## HERTFORDSHIRE ECOLOGY

**Application ID: S6/2014/1443/MA**

**Location: Land off Comet Way Hatfield**

**Description: Erection of new public house and associated works**

01 Landscaping Plan
1:100 @A1

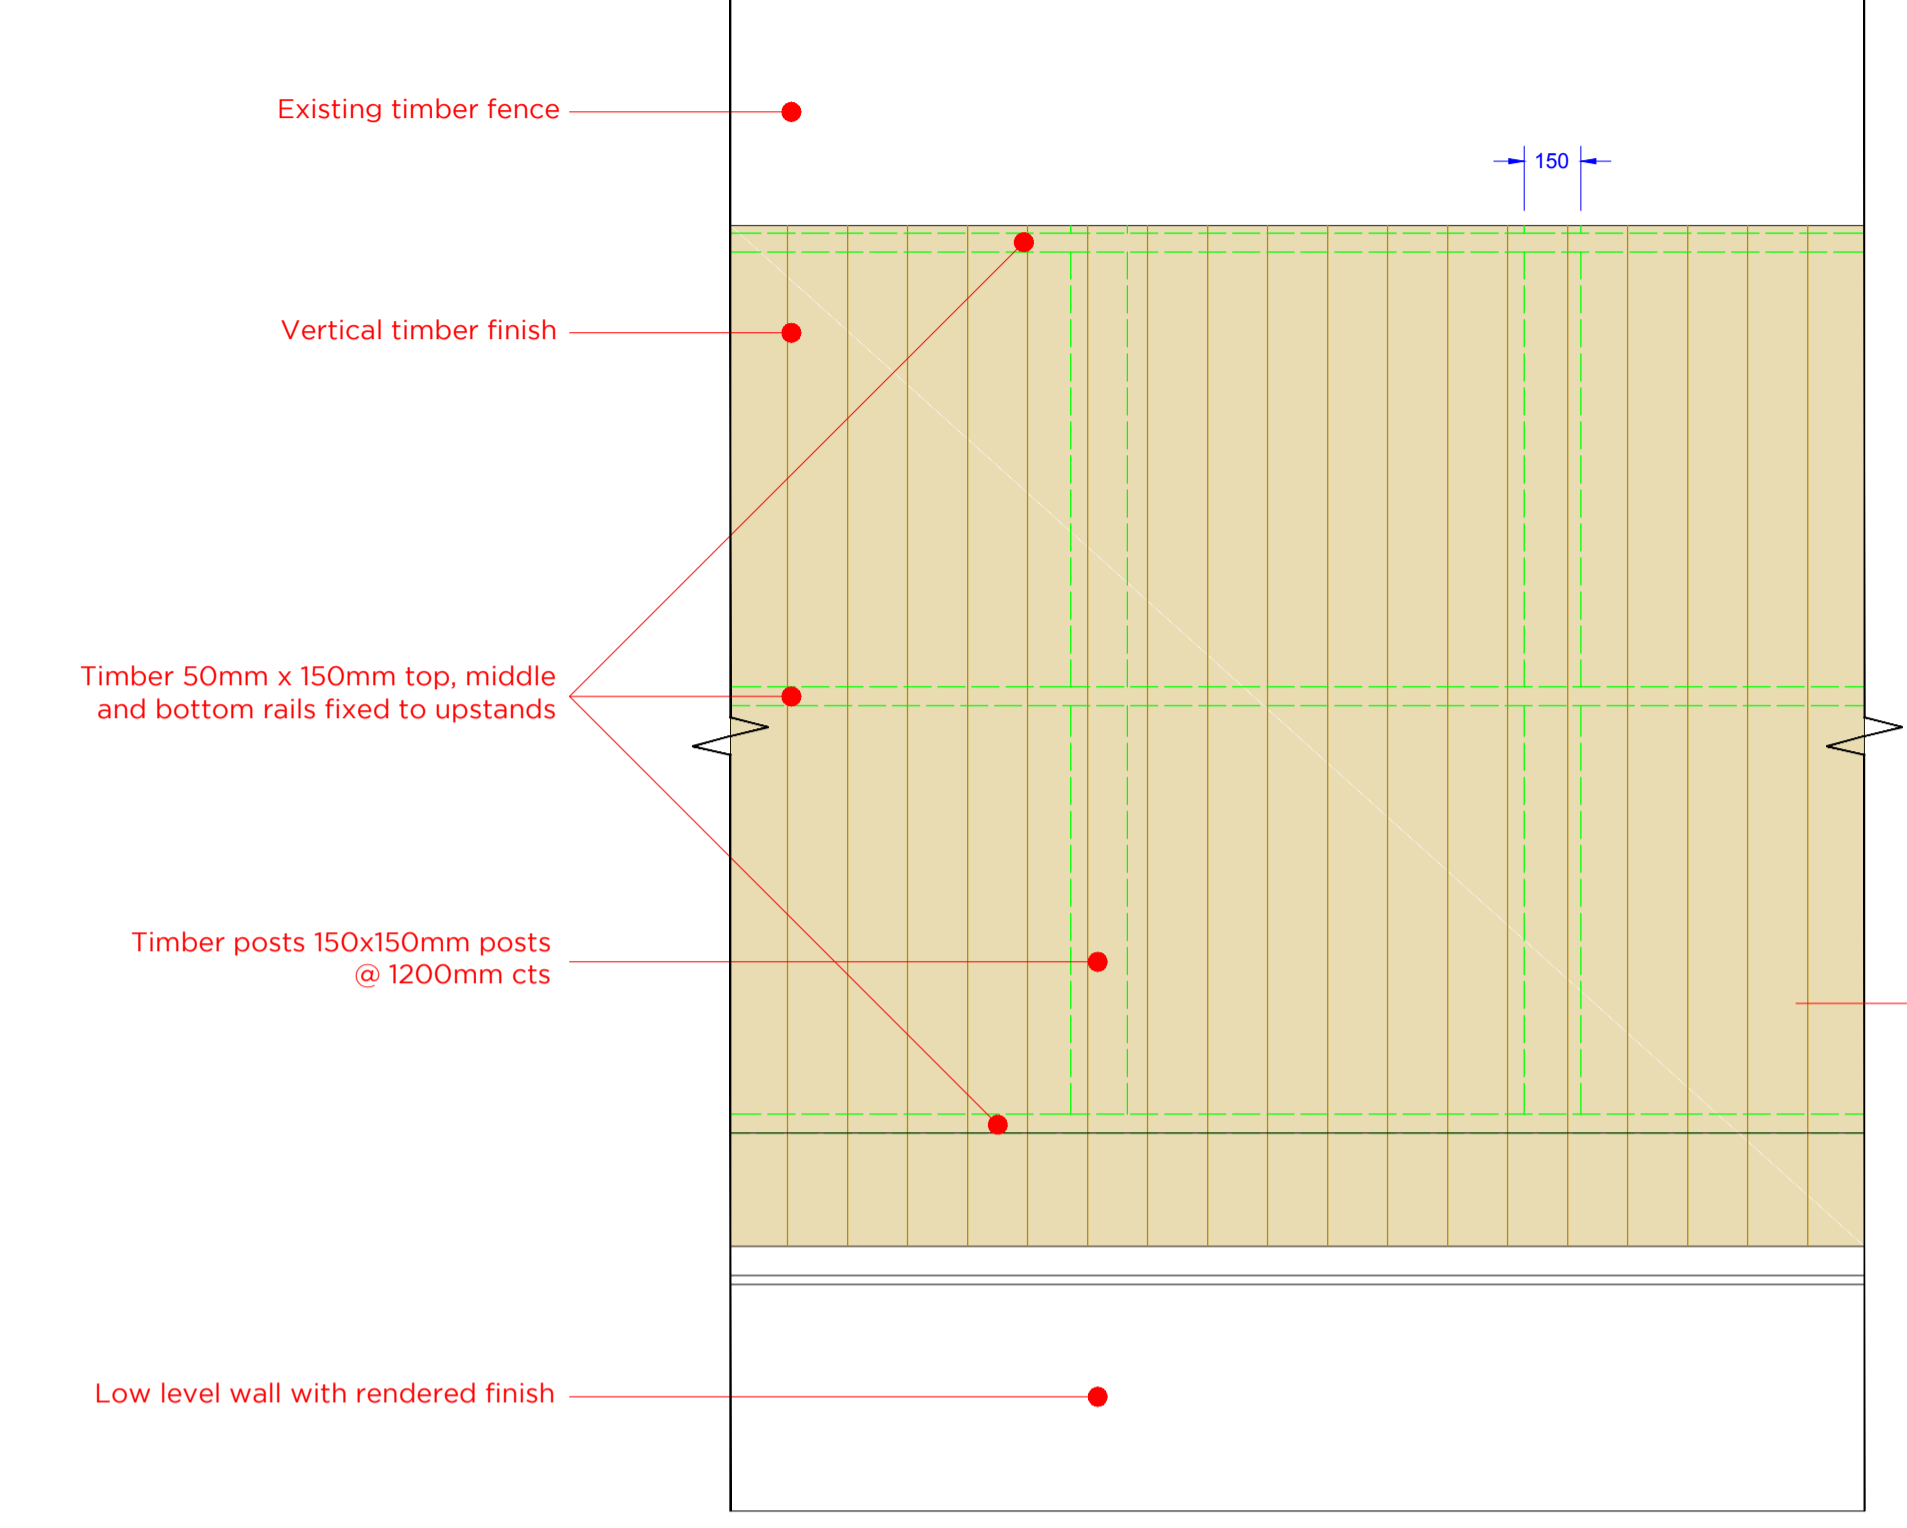
In area where new planting is proposed, I would like to see native fruit and seed bearing trees and shrubs, which will provide foraging habitats as well as nesting and cover opportunities for wildlife.
